**From:** Laura Gibbons <Laura.Gibbons@arun.gov.uk>  
**Sent:** 05 October 2021 12:04  
**To:** Planning.Responses <Planning.Responses@arun.gov.uk>  
**Cc:** Simon Davis <Simon.Davis@arun.gov.uk>  
**Subject:** RE: Planning Re-Consultation on: AL/112/21/DOC

Thank you for re-consulting us on this application. We have the following comments on conditions 10-12.

**Site Address:** Springfield Hook Lane Aldingbourne PO20 3TE  
**Grid Reference:** 493480 104546  
**Category:** Discharge of Condi  
**Description of Works:** Approval of details reserved by condition imposed under AL/64/20/PL relating to conditions 10-surface water drainage, 11-discharge of flows & 12-surface water drainage system maintenance & management.

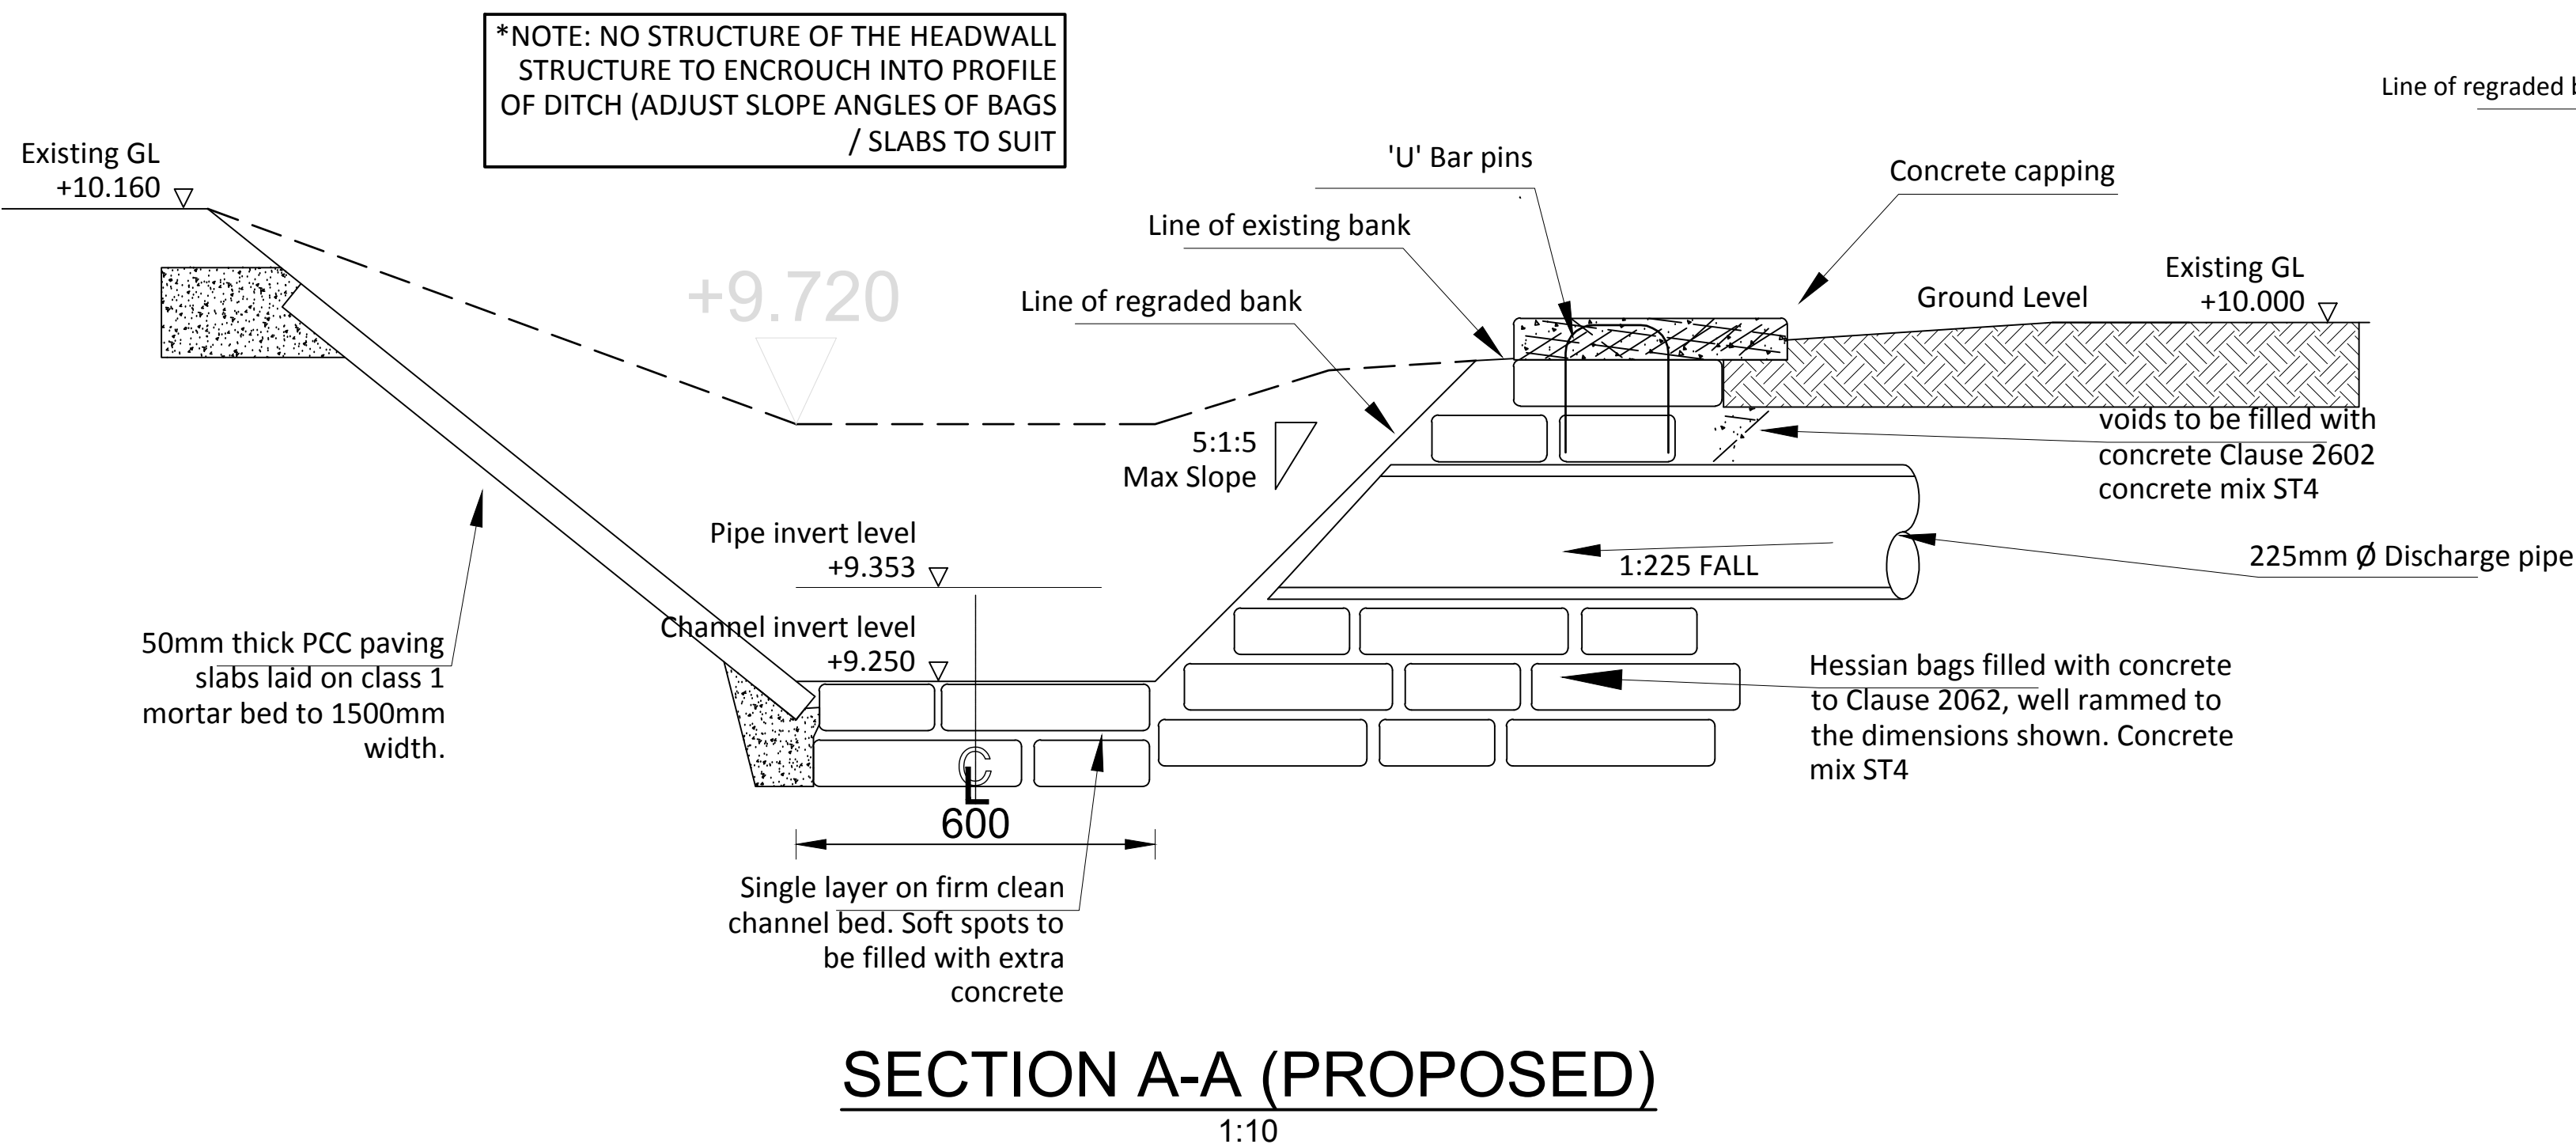
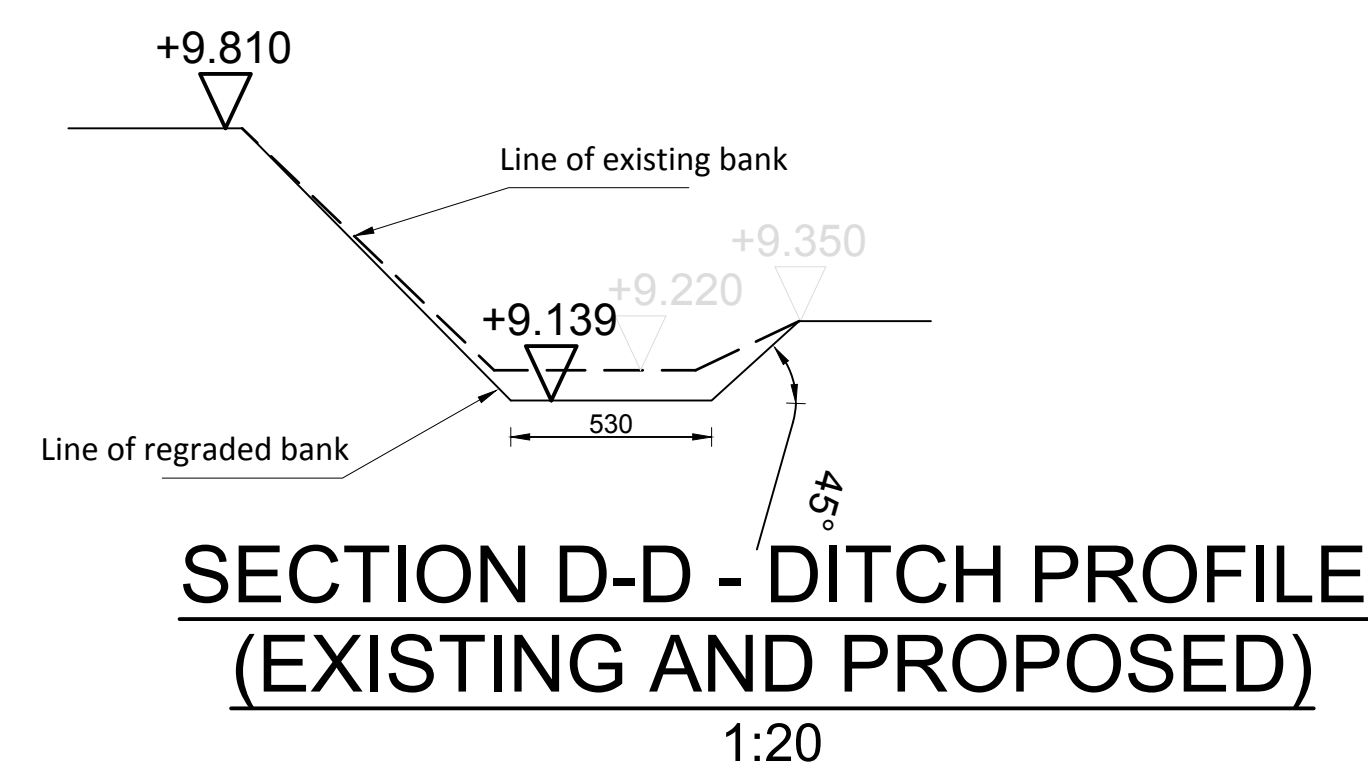
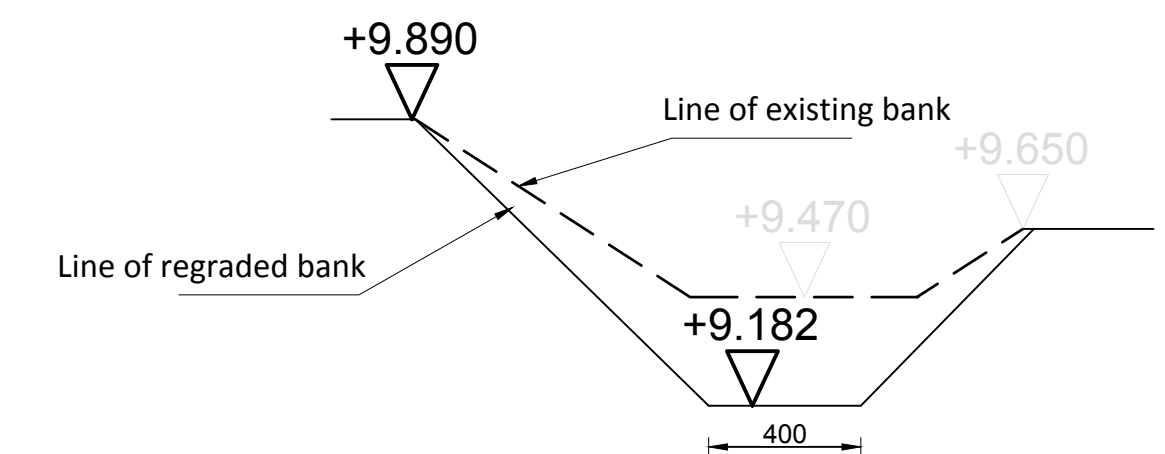
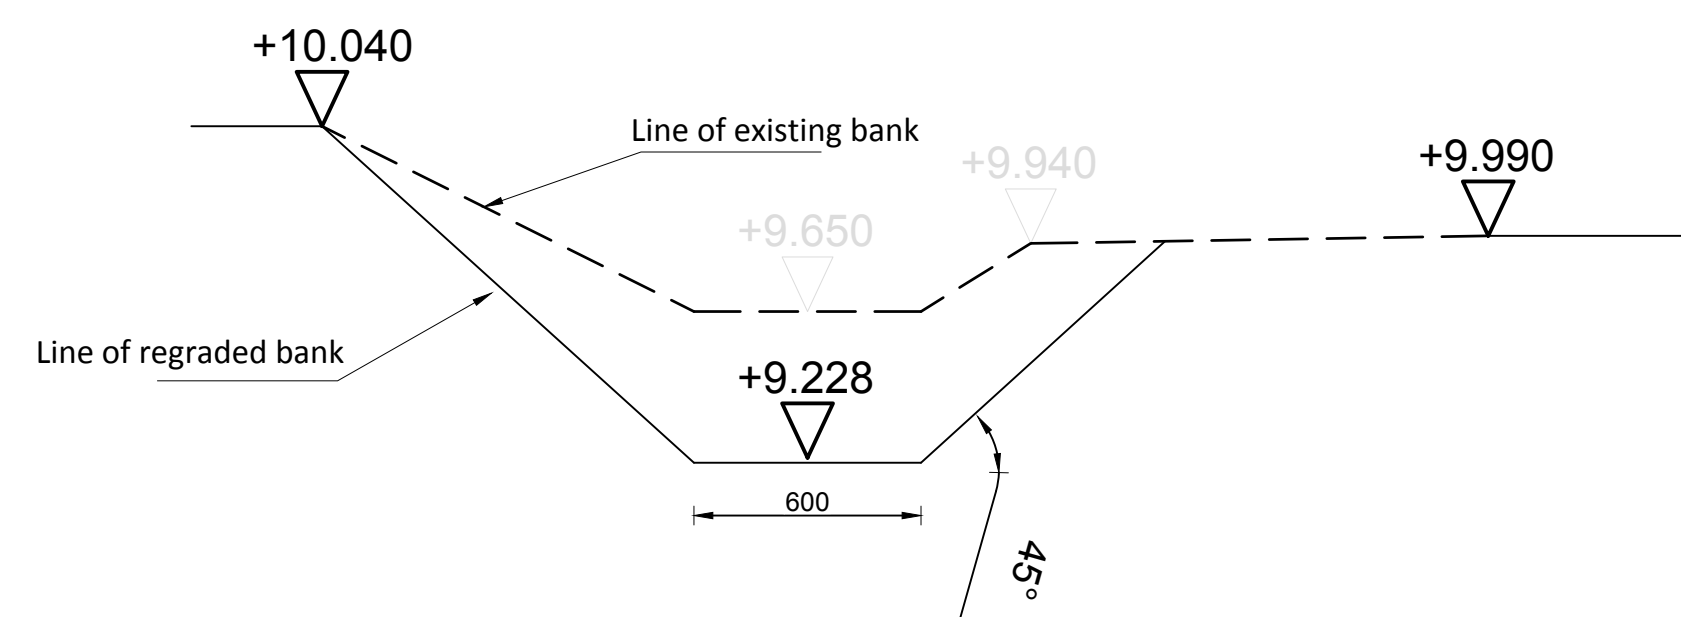
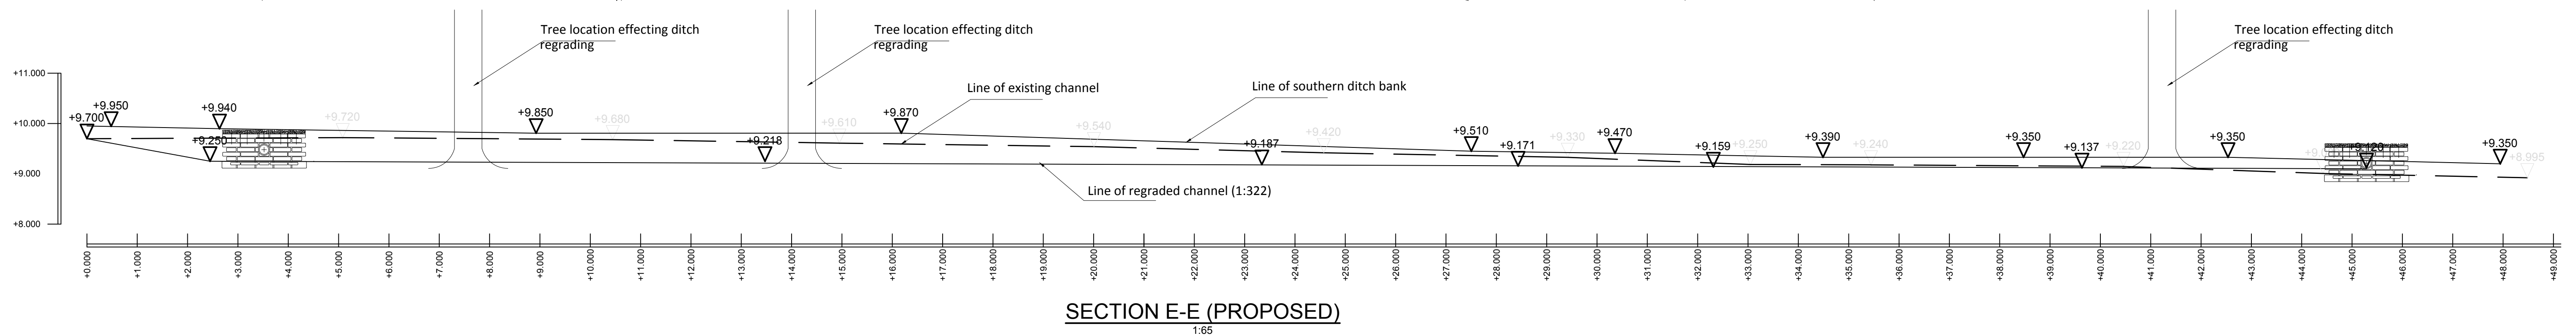
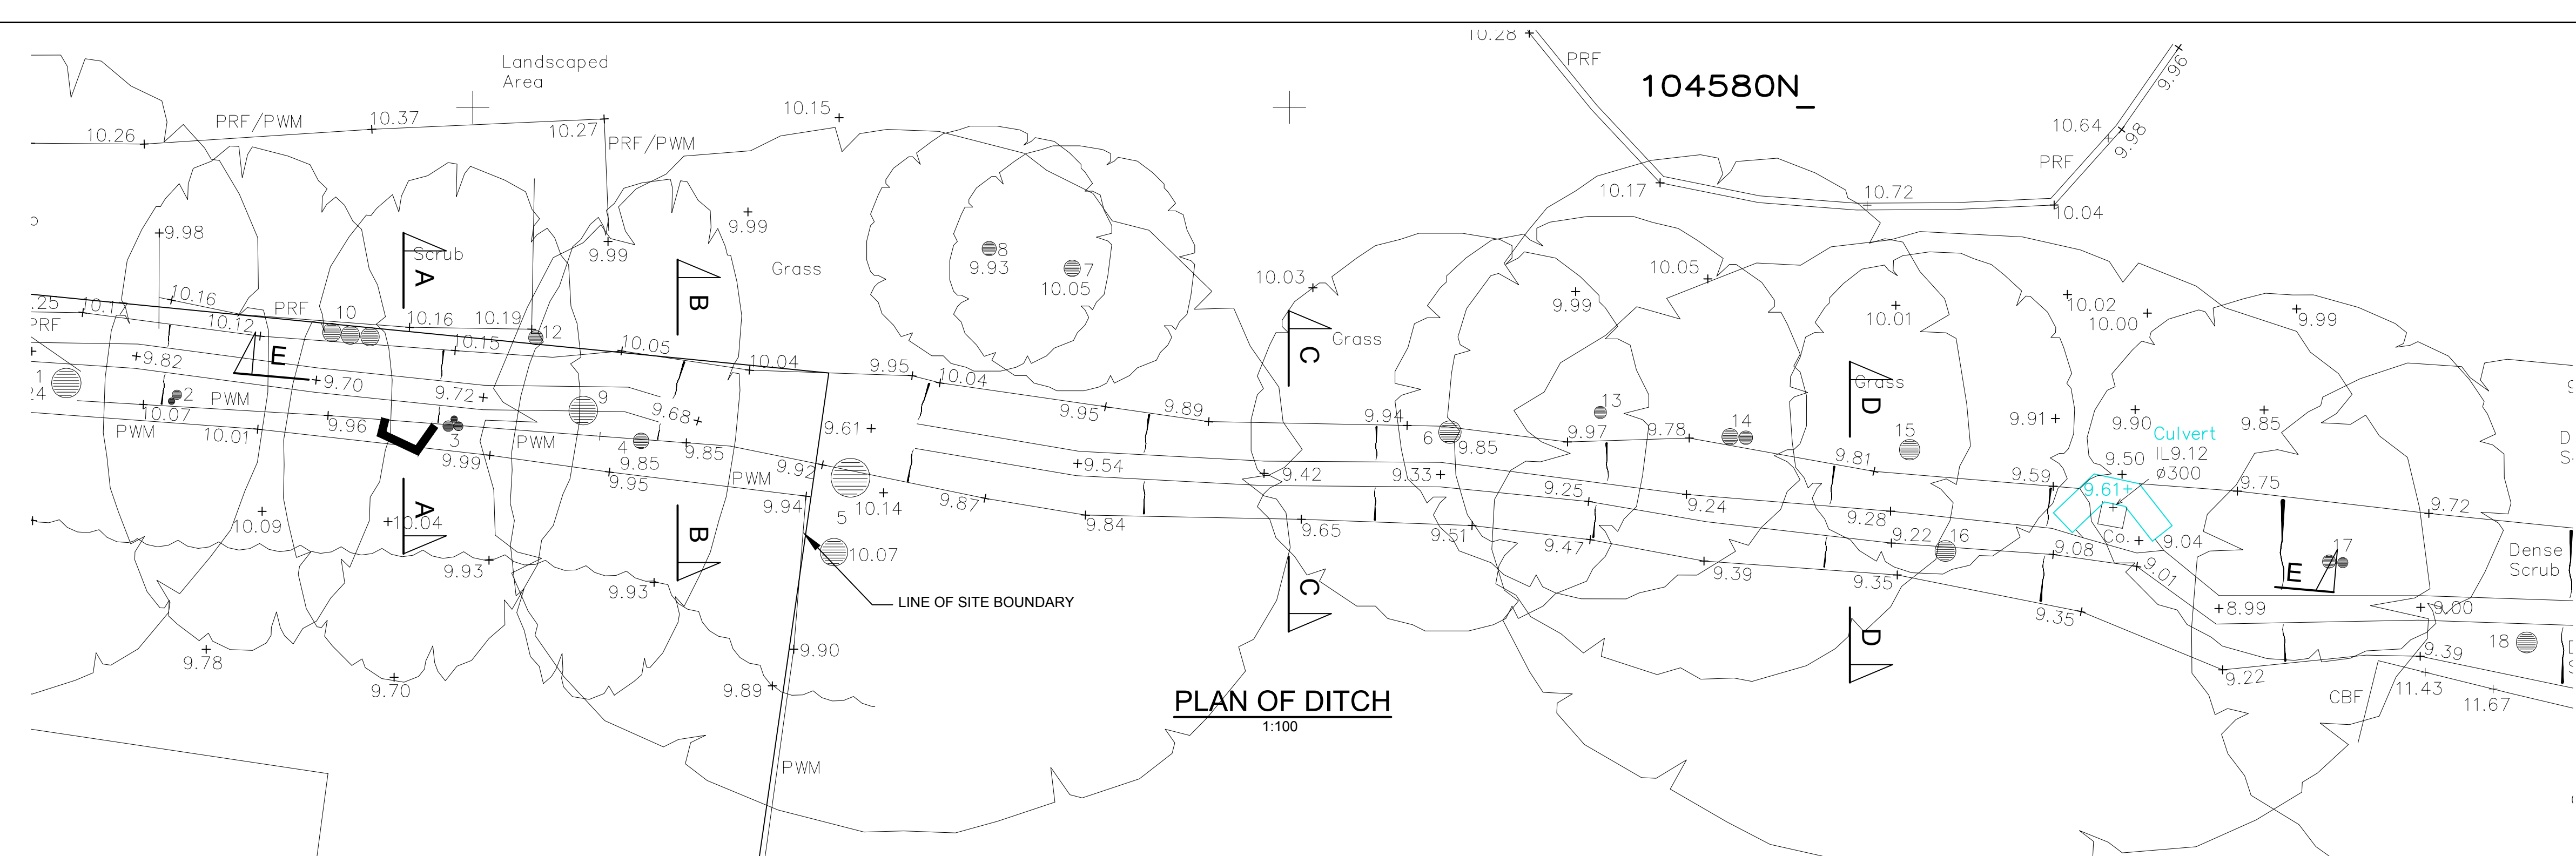
1. Calculations have now been submitted, however these do not include a surcharged outfall as requested previously (point 2 in response of 14<sup>th</sup> September). A surcharged outfall must be modelled with water level set to the top of bank of watercourse level.
2. Winter groundwater monitoring for the period 30/01/21 to 13/03/21 has been supplied. As have flotation calculations. These show the design to be adequate, even if groundwater rose slightly above that recorded.
3. The unit reference of the hydrobrake must be referenced on both the construction detail drawing and layout. Hydrobrake reference number must be consistent with calculations.

Please detail what section of watercourse the management company will have riparian responsibility for, include a plan in an appendix which clearly shows this. Please detail what riparian responsibility is and why maintenance of the ditch is important. Please update ditch maintenance table to remove references to elements which are not relevant, e.g. filter strip.
